## Engineers Comments Regarding Surface Water Drainage

| <b>Application Reference:</b>   | WA/57/26/DOC                                                                                                                               | <b>Reviewer Reference:</b> | ADC/EXT5/AF |
| <b>Site Name:</b>               | Walberton Farm Yapton Lane Walberton BN18 0AS                                                                                              |                            |             |
| <b>Application Description:</b> | Approval of details reserved by condition under WA/95/24/PL relating to conditions 3- Foul Sewerage and <b>4- Surface Water Drainage</b> . |                            |             |

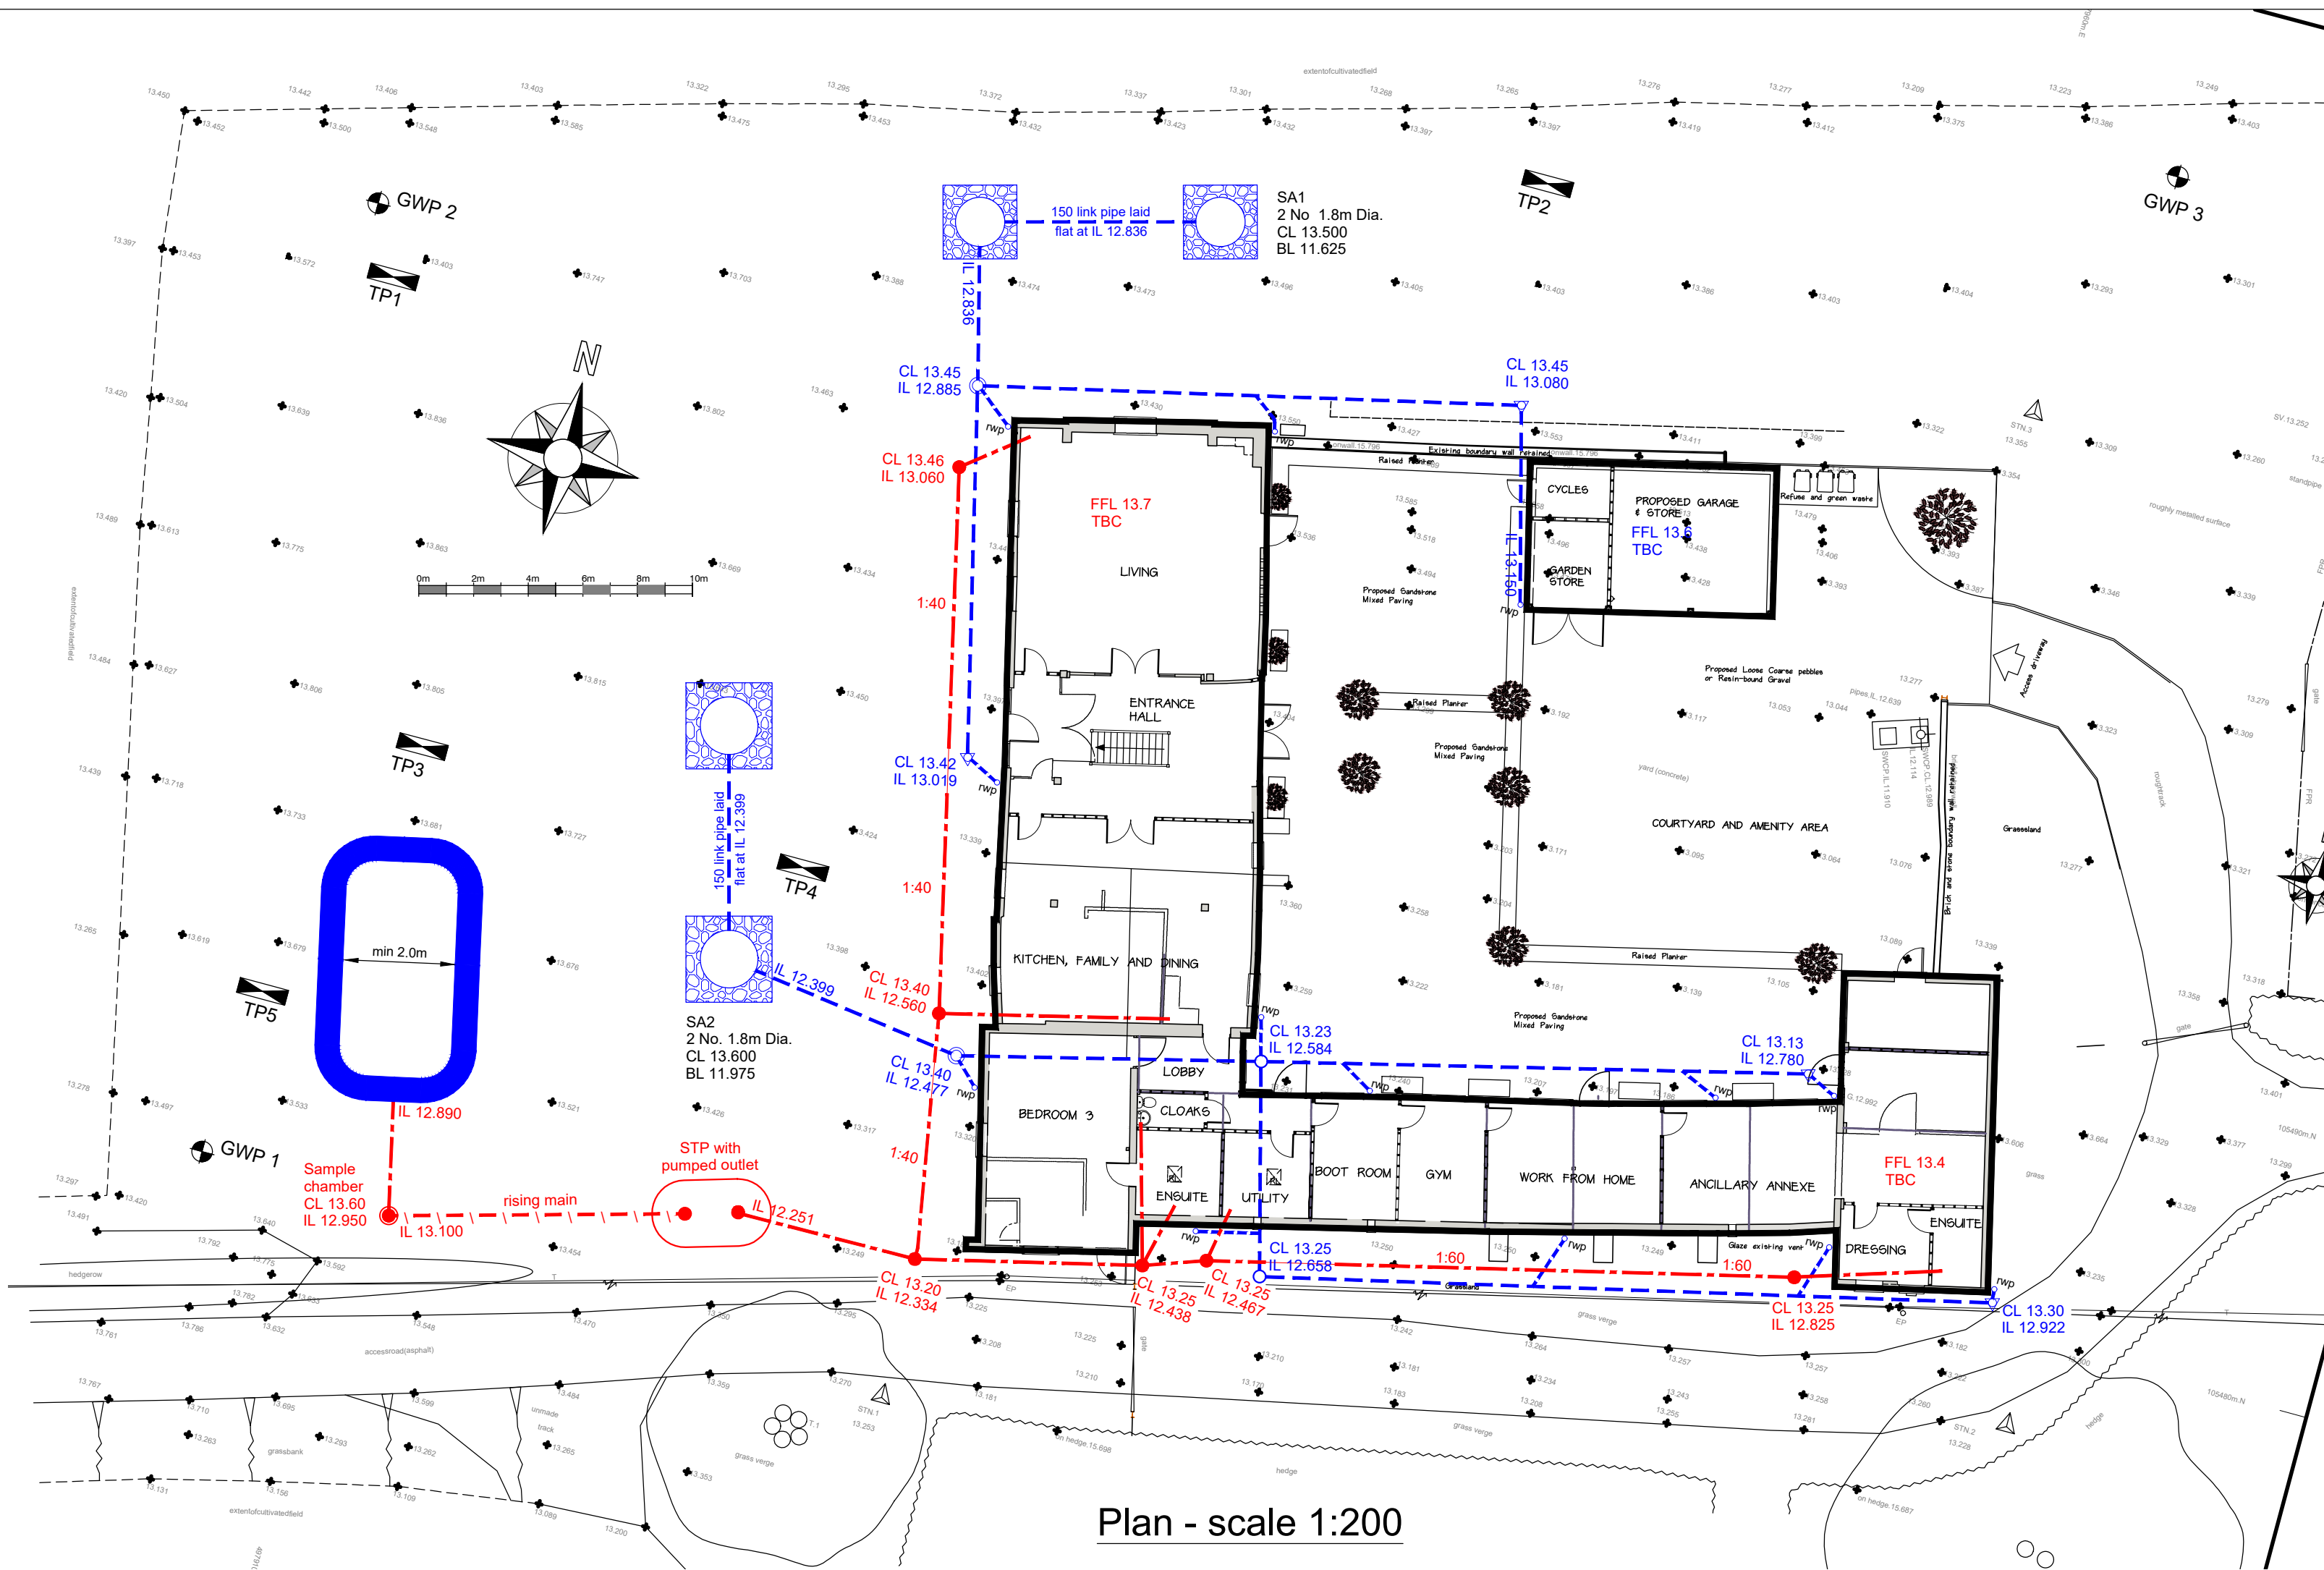
|                     | ADC Drainage Comments                                                                                                                                                                                                            | Designer Response |  |  |  |
|---------------------|----------------------------------------------------------------------------------------------------------------------------------------------------------------------------------------------------------------------------------|-------------------|--|--|--|
| 2.                  | The foul water drainage field should be moved to be 10m away from the surface water soakaways to separate infiltration zones.                                                                                                    |                   |  |  |  |

Impermeable areas plan Scale 1:500

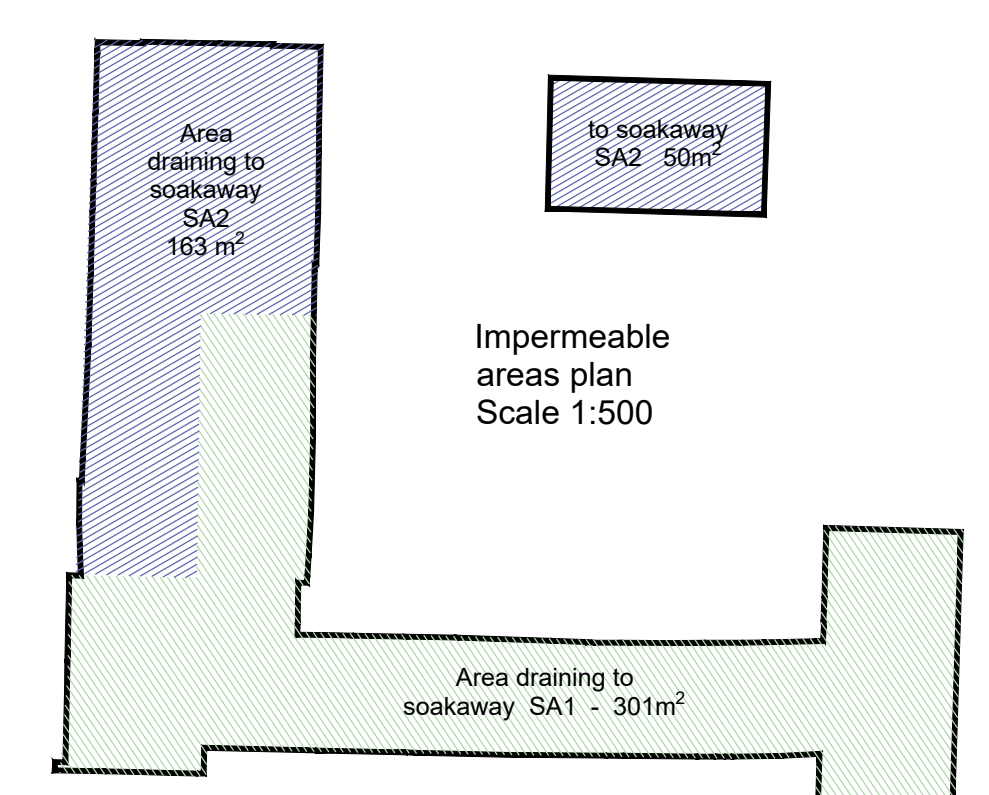
|                     | ADC Drainage Comments                                                                                                                                                                                                            | Designer Response |  |  |  |
|---------------------|----------------------------------------------------------------------------------------------------------------------------------------------------------------------------------------------------------------------------------|-------------------|--|--|--|
| 3.                  | An impermeable areas plan is required by the condition to verify the calculations.                                                                                                                                               |                   |  |  |  |
